From: ALBERT MARINER [REDACTED]
Sent: 29 July 2018 16:47
To: Planning
Subject: Additional Comments re A/36/18/OUT

Concentrating solely upon the replacement Transport Assessment;

DRAWING NUMBER: 2020-SP01	REVISION:
--	----------------------

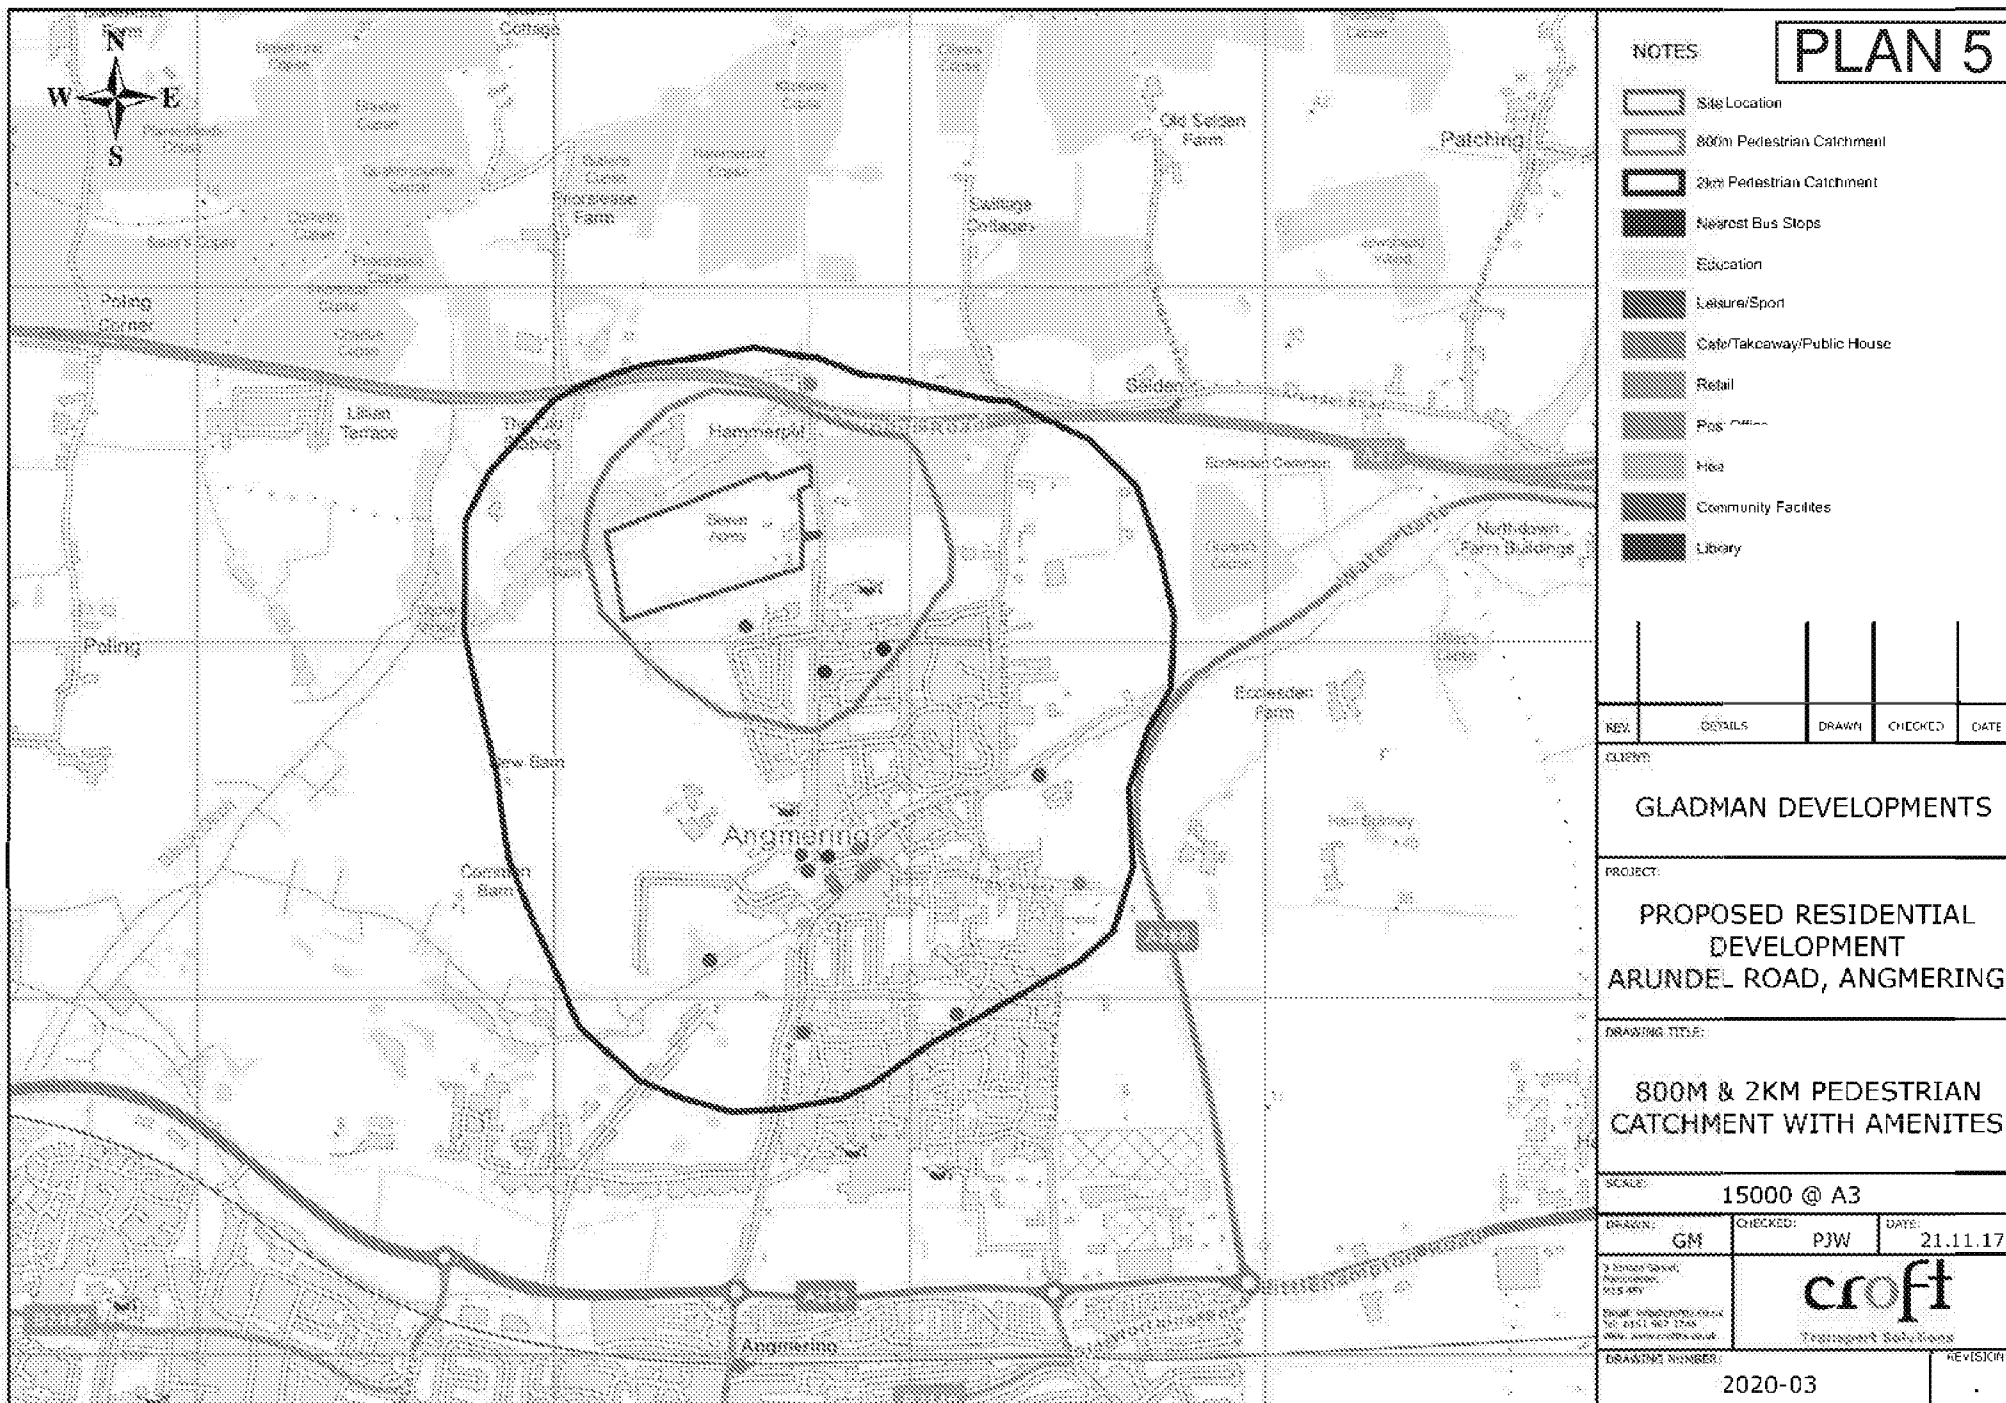
The Safety Audit covering the second (southernmost) potential access point, continues to raise concerns over encroachment of turning refuse (and any other similarly sized vehicles) accessing the site at this point. This is again dismissed by the designers, this time as being at a time when “vehicles turning into the site should be minimal”; this ignores the existing traffic which will be travelling south along Arundel Road to the two primary schools etc (as there is to be no ghost centre lane). Additionally, no consideration seems to have been given to the effect of the priority controlled traffic calming feature some 40 metres south of this entrance, where priority is afforded to northbound traffic. At peak times, even if existing traffic flows are ignored, once three or possibly four vehicles from the site are brought to a halt at this feature by northbound priority traffic, nothing will be able to exit the site. If this occurs when the refuse vehicle needs to enter the site, it would be unable to proceed and no traffic could flow at all.

The Safety Auditors’ comments relating to the encroachment of refuse vehicles into adjoining lanes at the proposed primary access, are dismissed by the engineers who imply that the encroachment would be “minimal.” This is not the view of the auditors, who are clearly and understandably, concerned as to the extent of encroachment displayed within the submitted Swept Path Analysis and show effectively complete occupation of opposing traffic lanes.
